## **PINS Deadline 2, 12<sup>th</sup> March 2026**

**From:** Tritton Farming Partnership LLP and its members and related parties, including Lowleys Farm (referred to as “TFP”). Reference Number NTOT-AFP1405 (& Other AFPs)

Additional comments since Deadline 1:

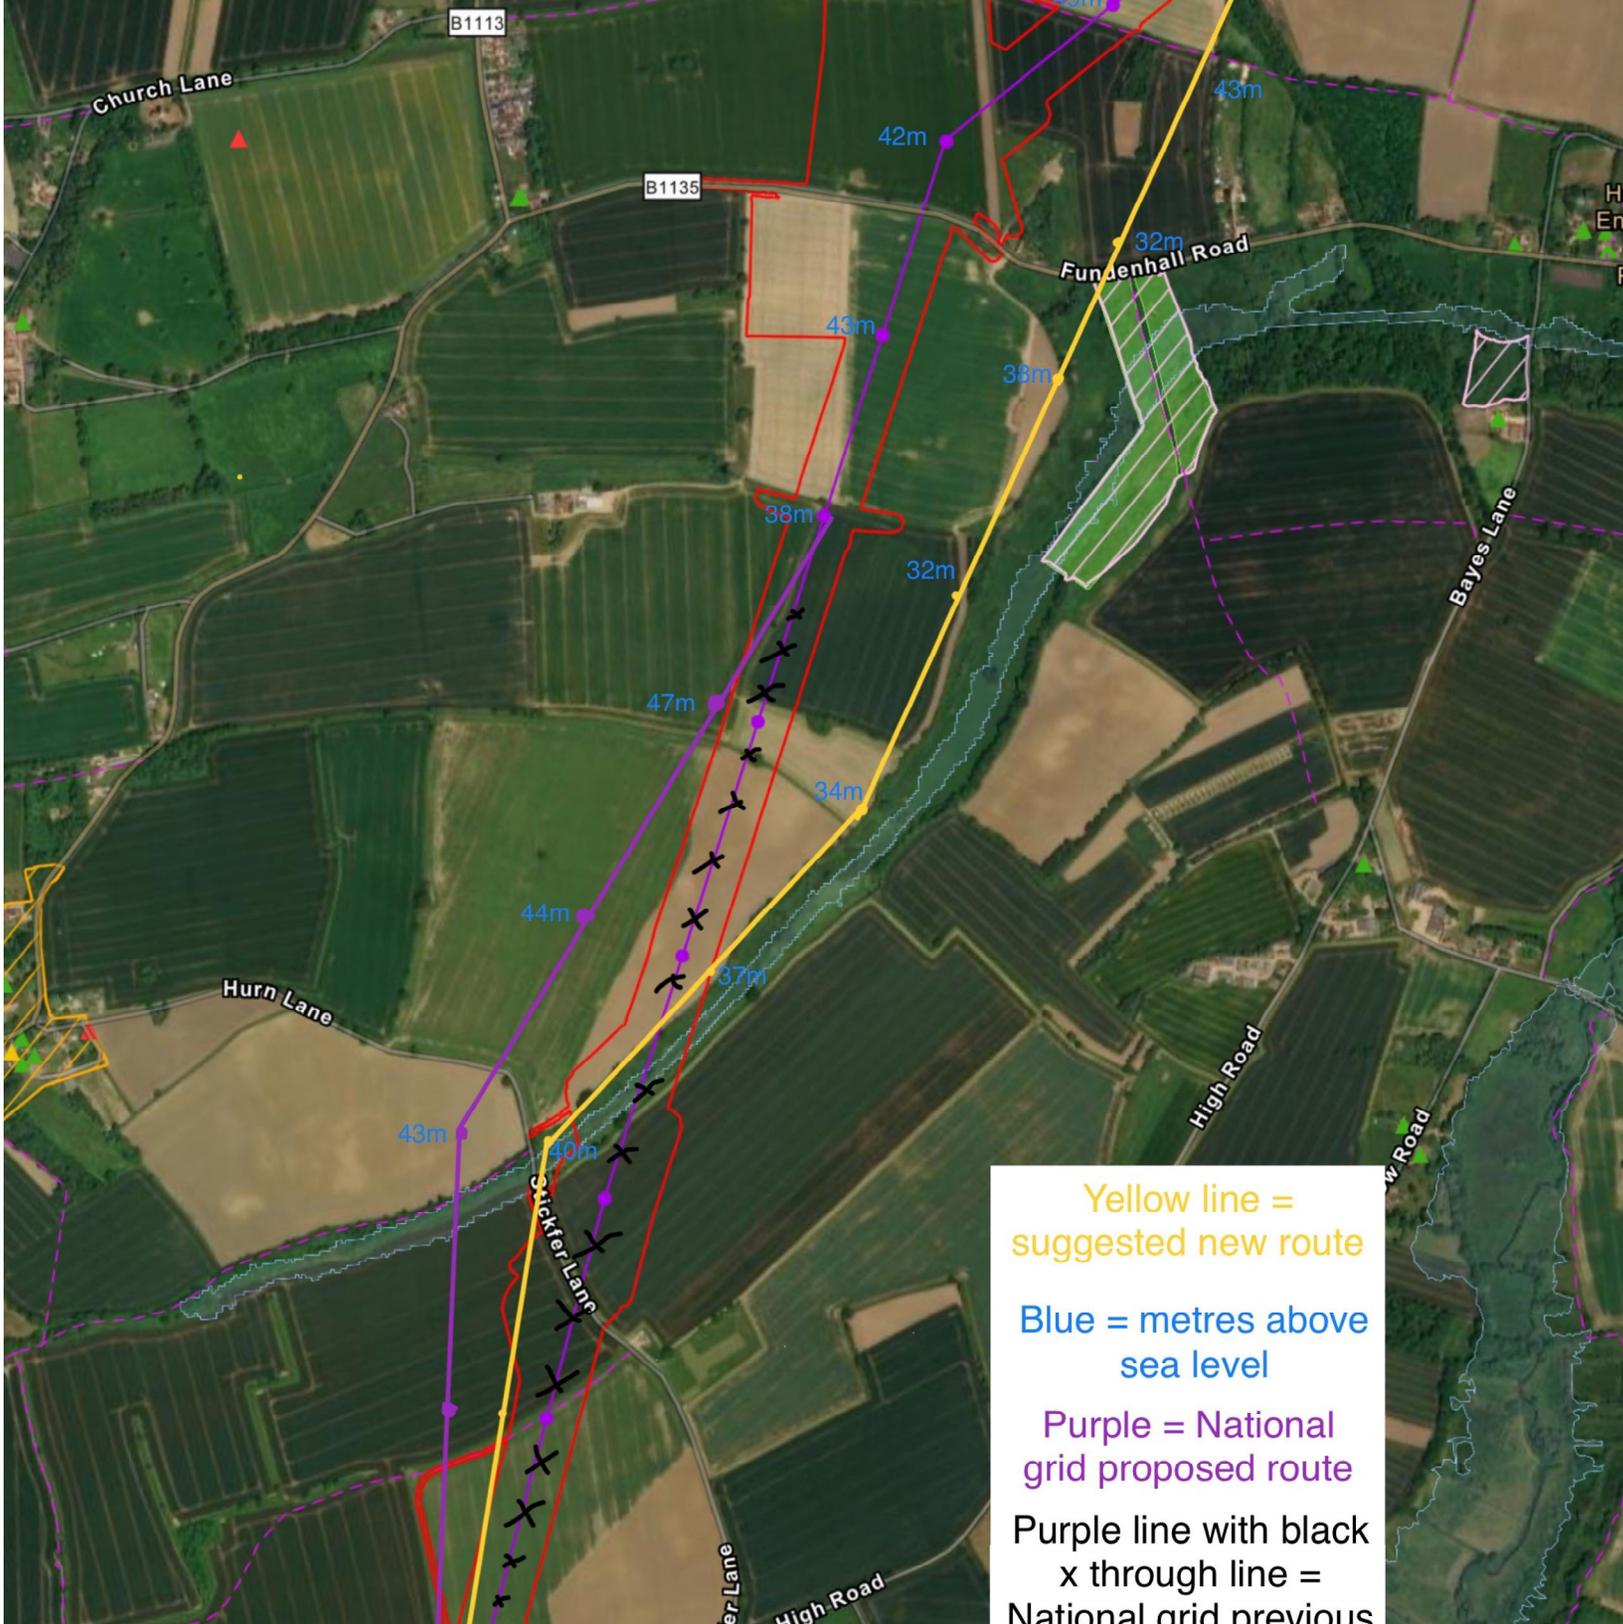
TFP supports Chelmsford City Council (“CCC”) proposal in their Deadline 1, Feb 2026 representation to move the Route to North of Waltham. Details of this route can be found at page 58, figure 5.13, Indicative alternative route of the Norwich to Tilbury Design Development Report June 2023.

The alternative route has the additional advantages of not crossing the Protected Lane of Goodmans Lane, raised by CCC, and takes the route further away from the River Ter SSSI, which is only 100m away from present route.

TFP would argue that NG’s Alternative Great Waltham Route, reduces compensation, heritage impact, environmental impact and avoiding development making it more Compliant with Holford Rules 1,2 & 7 with ShetI 2003 Clarifications. NG should once again investigate this alternative and its reasons for not choosing it now.

Figure 1 Scenario A and Scenario B of the Project in the vicinity of Lowleys Farm

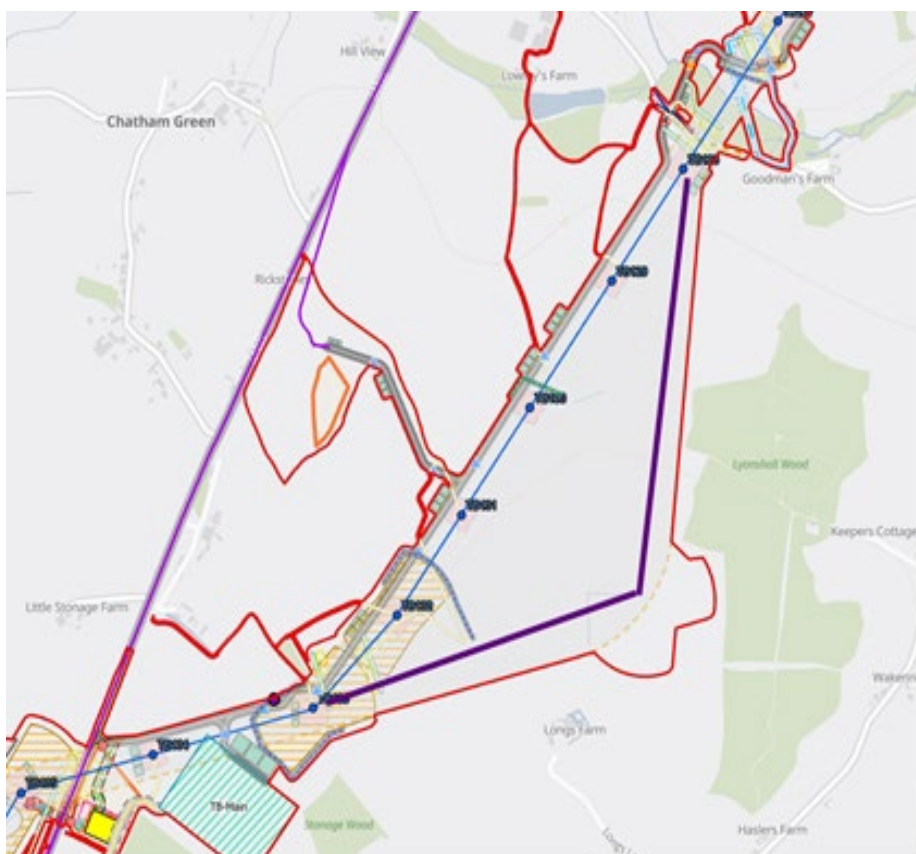
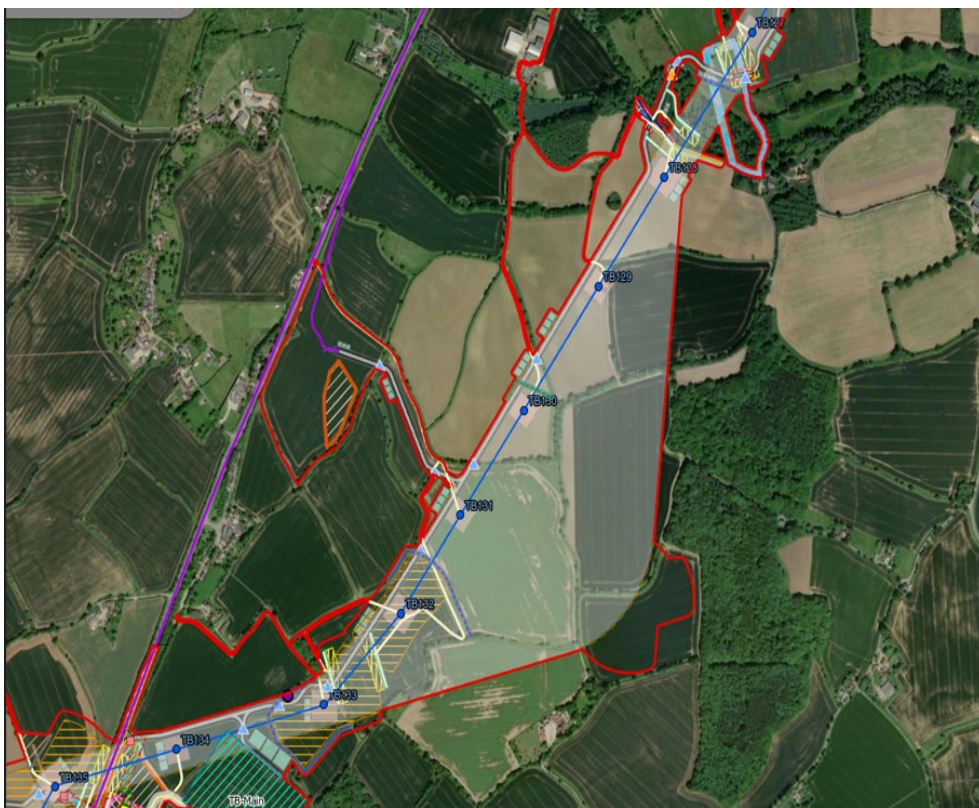
TFP’s preferred solution is to re-route to the “Great Waltham Alternative Route”, NG June 2023 or other routes. However, as a last resort TFP would support National Grid Route B over Route A at Lowleys (Tritton Farming Partnership, aka Lions Minerals) on page 31 of National Grid Document: 8.6.1 Deadline 1 Cover Letter (Planning Inspector Reference EN020027). TFP, however, notes that Route B details are insufficient at this stage for TFP to fully comment on and proposed surveys etc. do not include the area of Route B.
